Report of the Head of Planning, Sport and Green Spaces

Address 78 HIGH STREET NORTHWOOD

Development: Conversion of existing Retail Unit to create 2 x 2-bed apartments (Class C3) under Class M of the Town and Country Planning (General Permitted Development) (England) Order 2015 (as amended).

LBH Ref Nos: 32265/APP/2021/710

Scale	Dwg No.
1:100 @ A3	FLU.1441.03
Date	Rev
06.02.21	
Drawn	
N.Millin

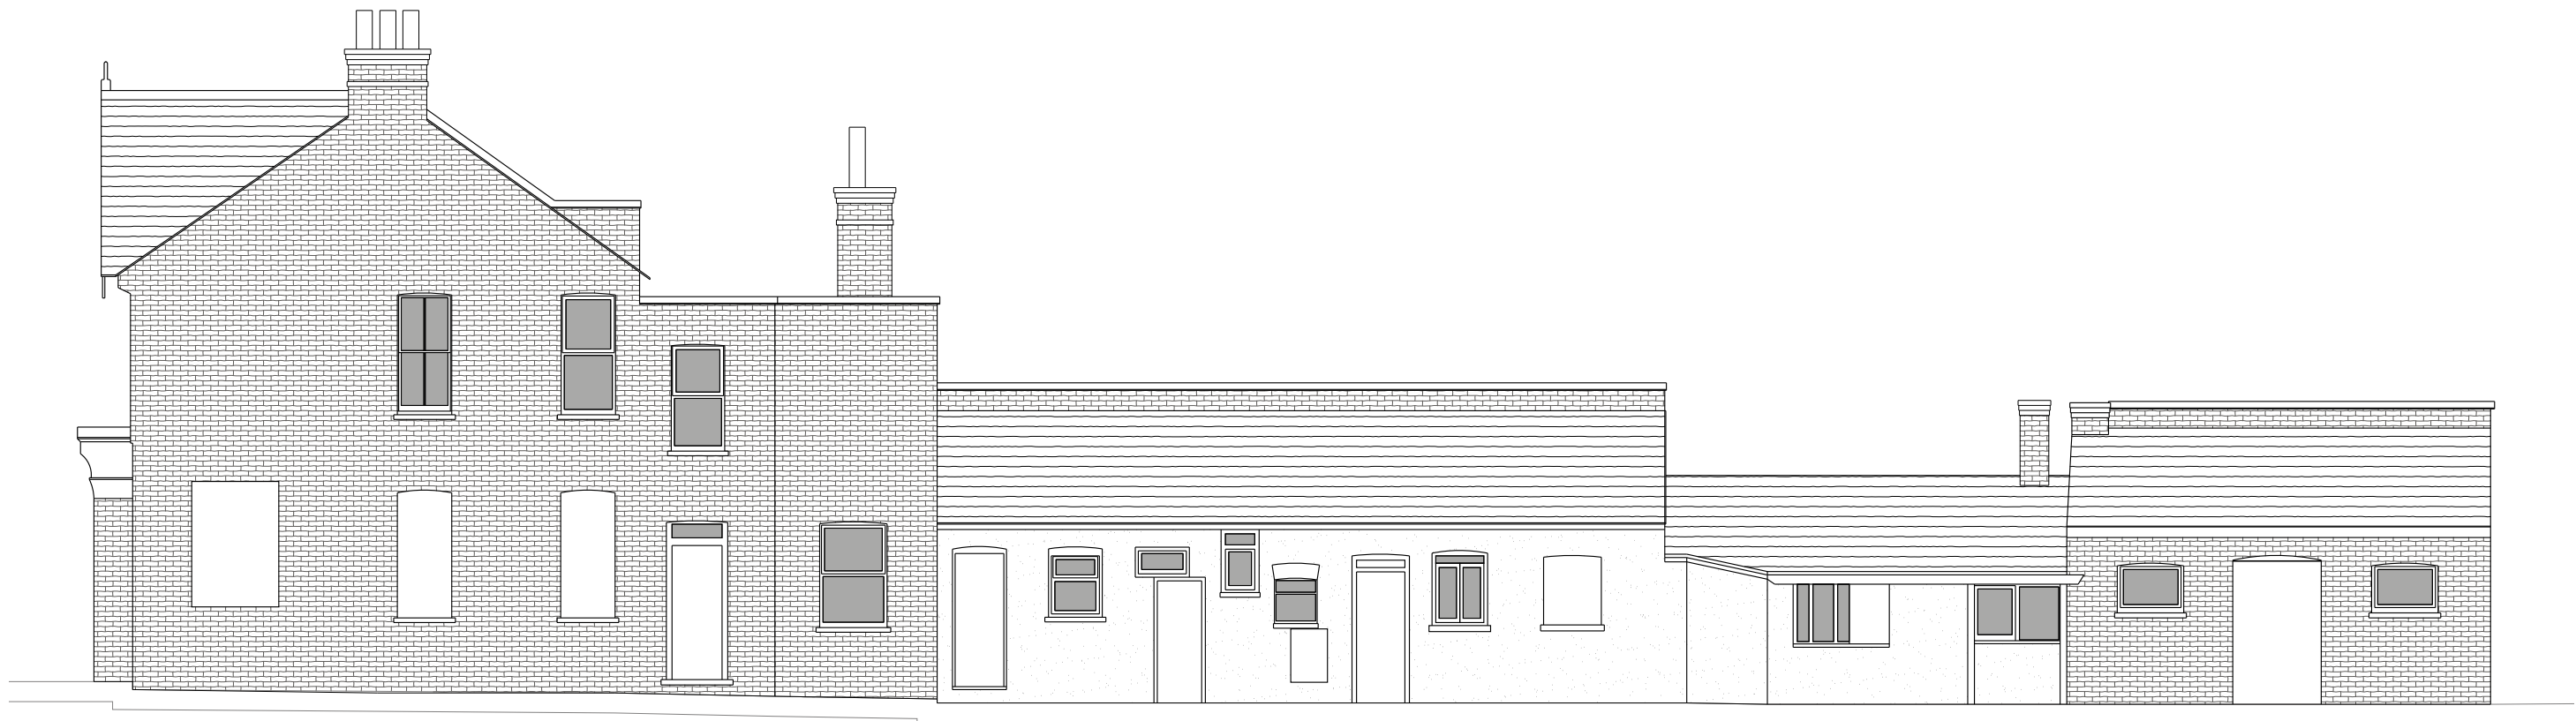
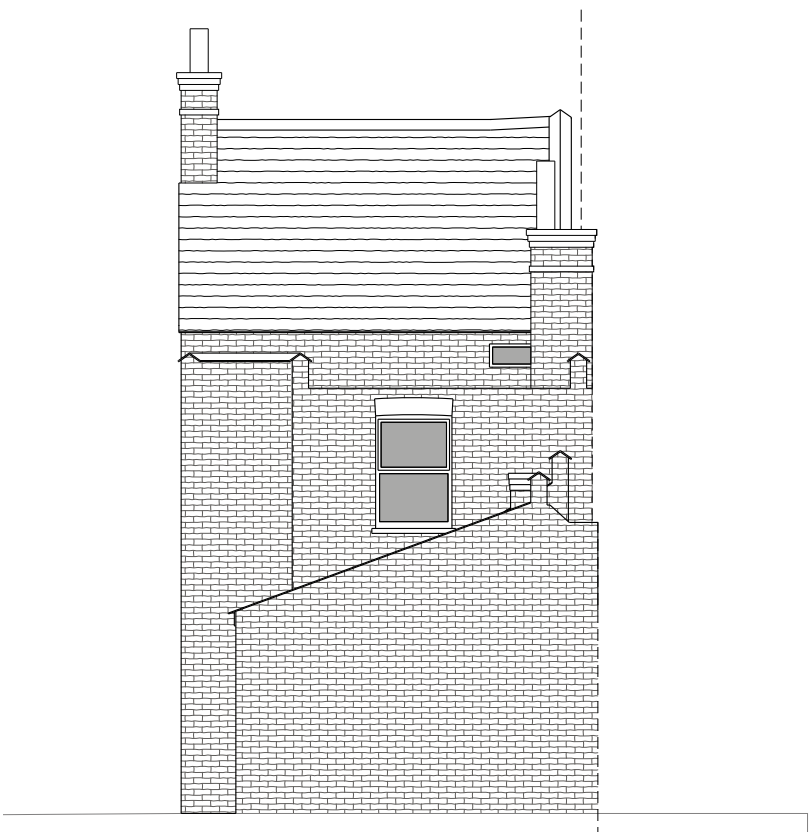
Under Part M of the GPDO an assessment of the impact upon the external appearance of the property can also be made. The plans demonstrate that there would not be significant alterations to the exterior of the building as a result of the development. As such there are no objections to this aspect of the proposal.
